Recommendation Report for Planning Permission for Works or Extension to a Dwelling

REF NO: P/97/19/HH

LOCATION: Manoss Lea
9 Manor Park
Pagham
PO21 3JS

PROPOSAL: Alterations and extensions to dwelling- including single storey front extension and new roof.

EX AND PRO ROOF PLANS
SITE PLAN
PROPOSED ELEVATIONS
SEPT 2019
1-100, 1-200, 1-500 DEC 2

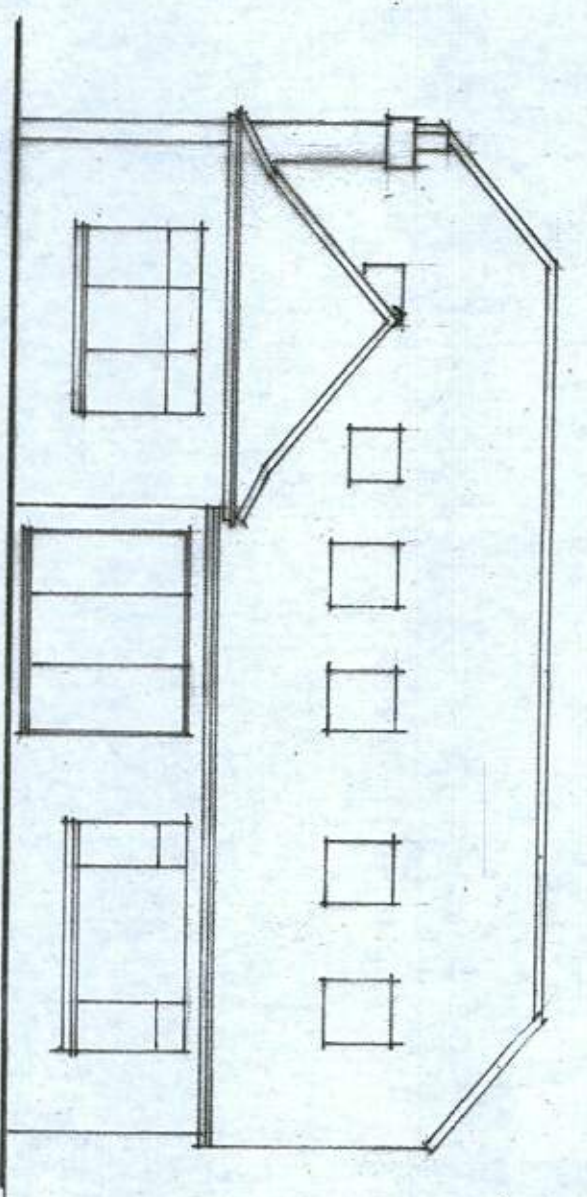
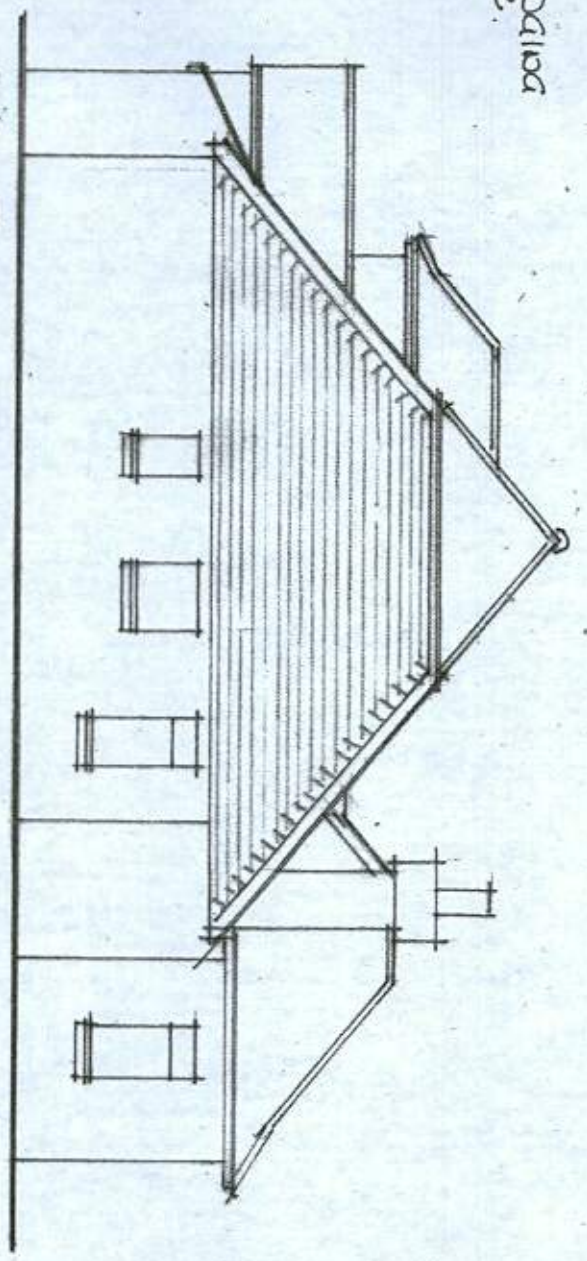
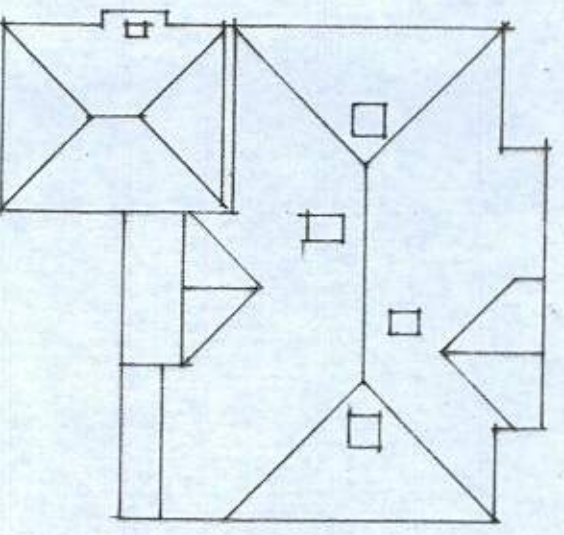
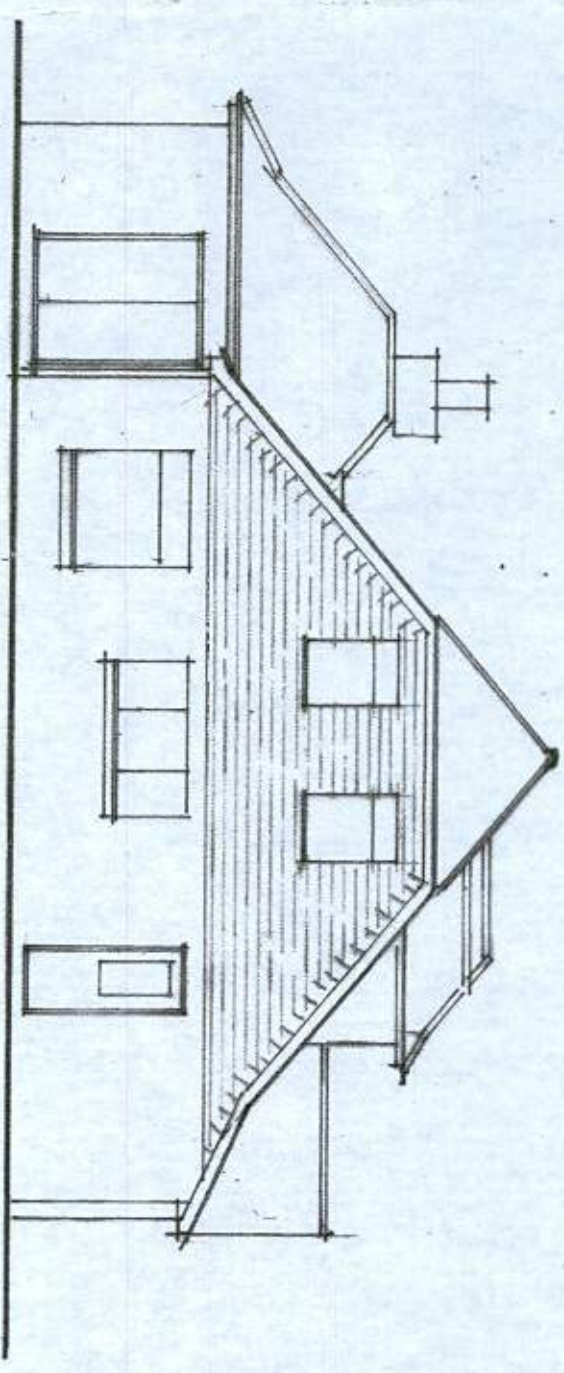
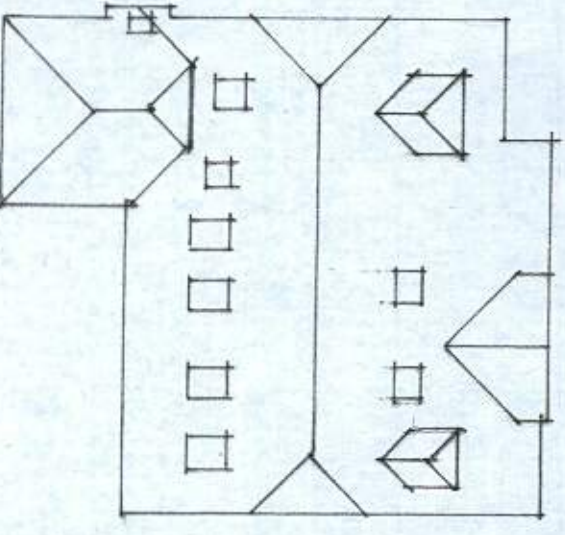
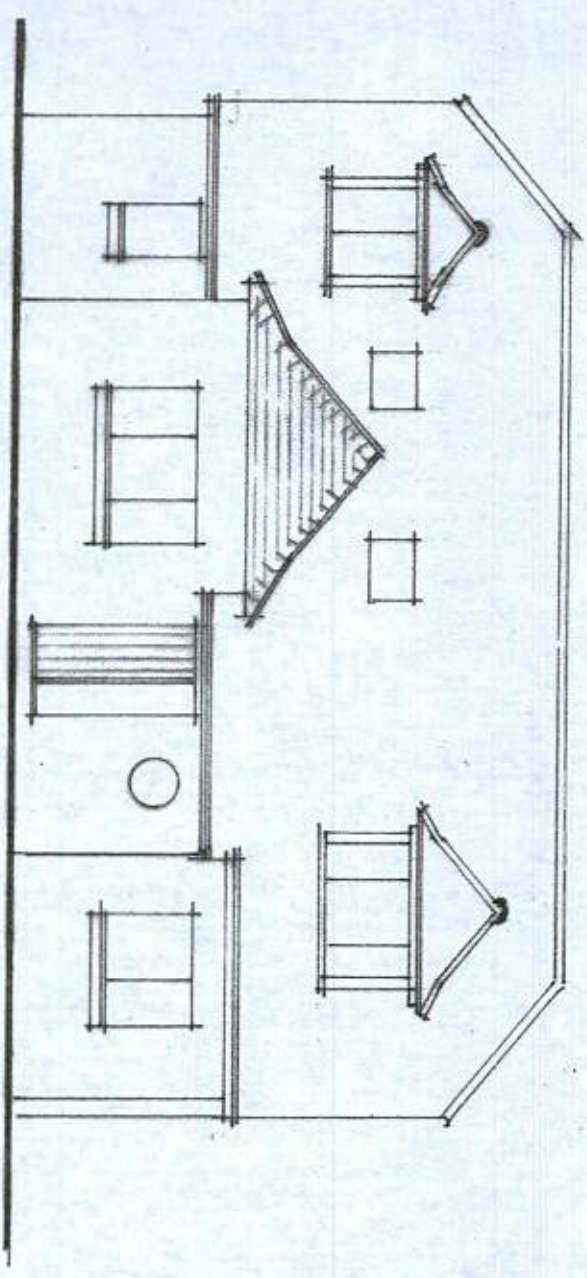
There will be a small extension to the northern elevation however this is modest at a depth of 1.25m and meets with the existing principal elevation. The roof height will also increase in height by approximately 1m and the roof design will alter from a hipped to barn hip end. The dwelling is however not considered to appear unduly dominant upon the street scene, in such that the roof height will be similar to that of the neighbouring property. A new property was constructed to the west of the host dwelling in 2017. The proposal seeks to alter the host dwelling in such that the appearance will be similar in design and scale to that of the neighbouring dwelling.

There will also be 2 pitched roof dormers to the northern elevation. These are modest in size and appear sympathetic in appearance to the host dwelling with an existing small pitch gable retained to the front elevation.

The materials proposed include tile hanging to the gable ends and render to the ground floor. The dwelling will appear similar to that of the neighbouring property to the west and with cladding located at properties to the north east, is not considered out of character for the area.

The dwelling will increase in roof height from approximately 6.1m to 7.1m. The neighbouring property to the west is already of a larger scale and the alterations are therefore not considered to result in the property appearing overbearing or overshadowing. There is a bungalow situated to the south east however the host dwelling is situated around 7m away from the boundary and as a result of the siting and the sufficient boundary treatment in place, again it is not considered to give rise to adverse overbearing or overshadowing impacts. There is a bungalow located to the rear of the dwelling however, due to the siting is again not considered to appear adversely overbearing.

As a result of the increase in height there are additional windows proposed. There will be 2 additional velux to the east however due to the siting of the neighbouring property which is situated slightly behind the host dwelling and the separation distance, they are not deemed to result in adverse overlooking. To the rear of the dwelling there will also be a number of additional velux. 4 out of the 6 will serve a bathroom and landing and are not deemed to result in adverse overlooking. The remaining 2 serve a bedroom and due to their siting to the eastern side of the rear may have the potential to give rise to overlooking at No.10 and will be conditioned to remain obscured glazed however not fixed shut. There will also be 2 dormers to the northern elevation and an additional velux however these will overlook the

- 3 The two velux windows serving a bedroom to the south eastern elevation of the building shall at all times be glazed with obscured glass.
